Subject: 3rd Party Planning Application - 21/03177/F

Our DTS Ref: 54862
Your Ref: 21/03177/F

Re: Axis J9 Phase 3, Howes Lane, Bicester, Oxfordshire, OX26 2GT

Phase 3 FW Drainage Layout 1:1000

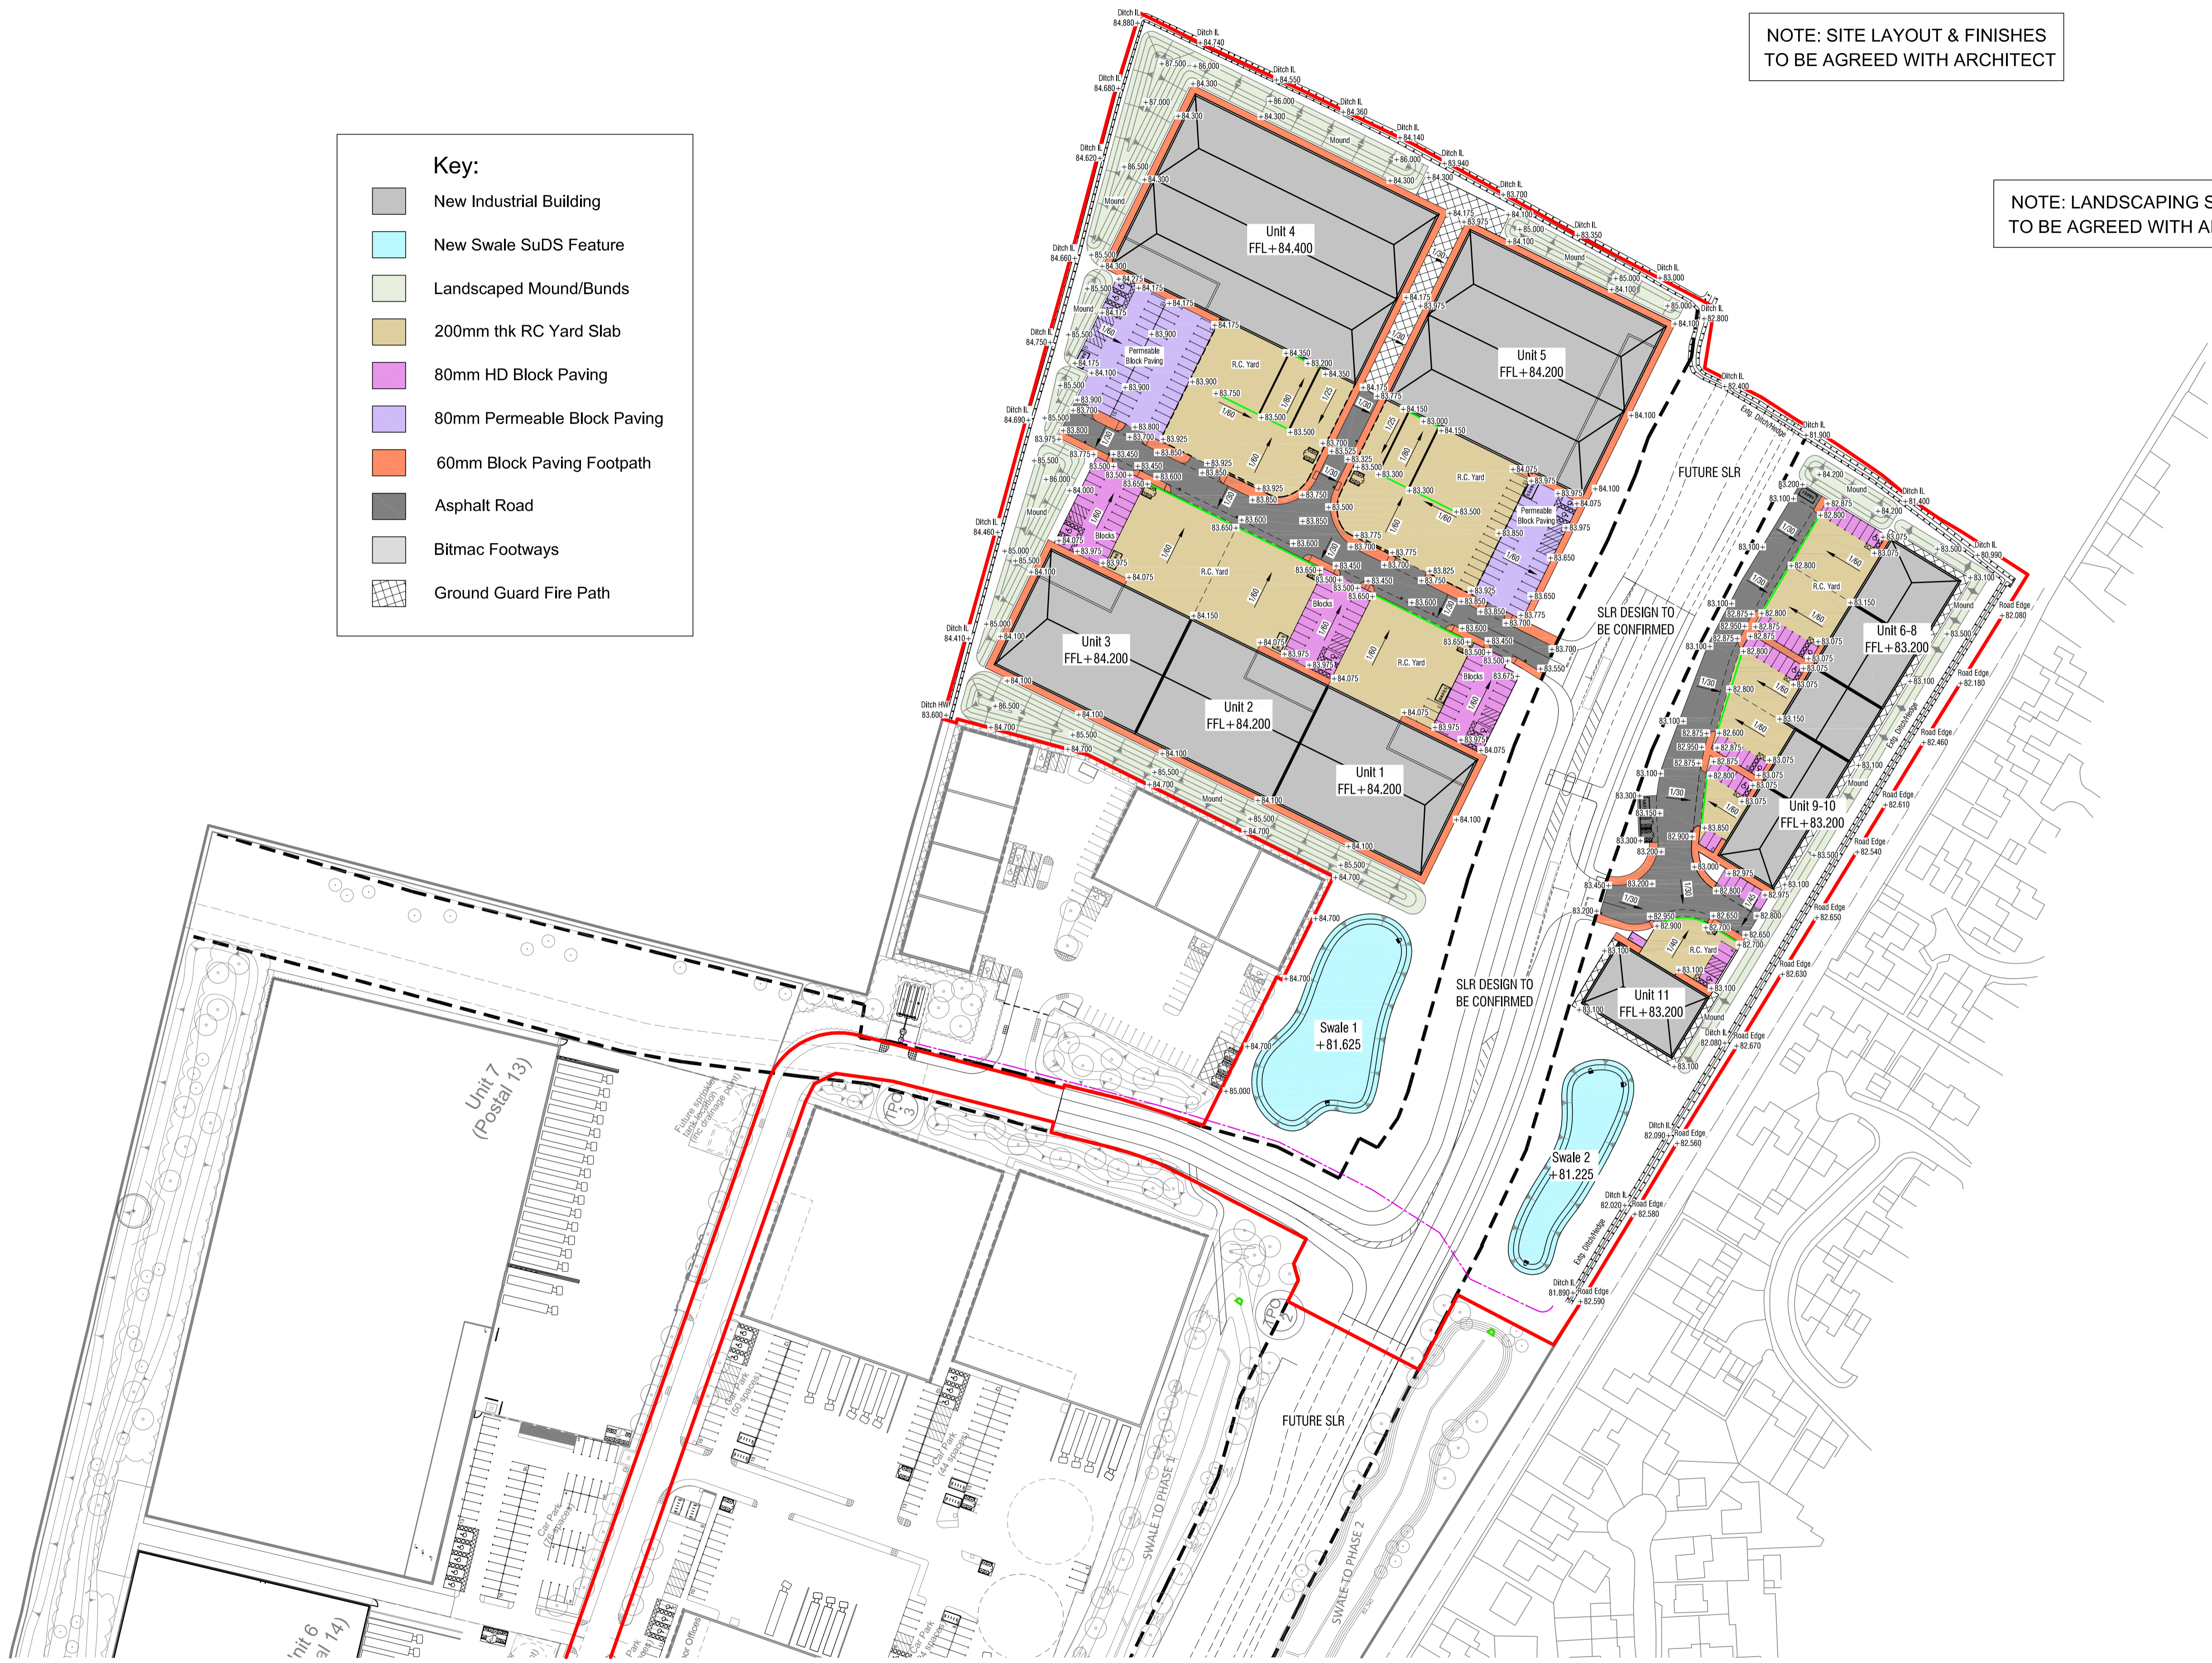
With the information provided, Thames Water has been unable to determine the Foul water infrastructure needs of this application. Thames Water has contacted the developer in an attempt to obtain this information and agree a position for FOUL WATER drainage, but have been unable to do so in the time available and as such, Thames Water request that the following condition be added to any planning permission. "No development shall be occupied until confirmation has been provided that either:- 1. Foul water Capacity exists off site to serve the development, or 2. A development and infrastructure phasing plan has been agreed with the Local Authority in consultation with Thames Water. Where a development and infrastructure phasing plan is agreed, no occupation shall take place other than in accordance with the agreed development and infrastructure phasing plan, or 3. All Foul water network upgrades required to accommodate the additional flows from the development have been completed. Reason - Network reinforcement works may be required to accommodate the proposed development. Any reinforcement works identified will be necessary in order to avoid sewage flooding and/or potential pollution incidents. The developer can request information to support the discharge of this condition by visiting the Thames Water website at thameswater.co.uk/preplanning. Should the Local Planning Authority consider the above recommendation inappropriate or are unable to include it in the decision notice, it is important that the Local Planning Authority liaises with Thames Water Development Planning Department (telephone 0203 577 9998) prior to the planning application approval.

Please could the developer confirm where they would like to connect to the foul water network and whether this would be a pumped or gravity connection.
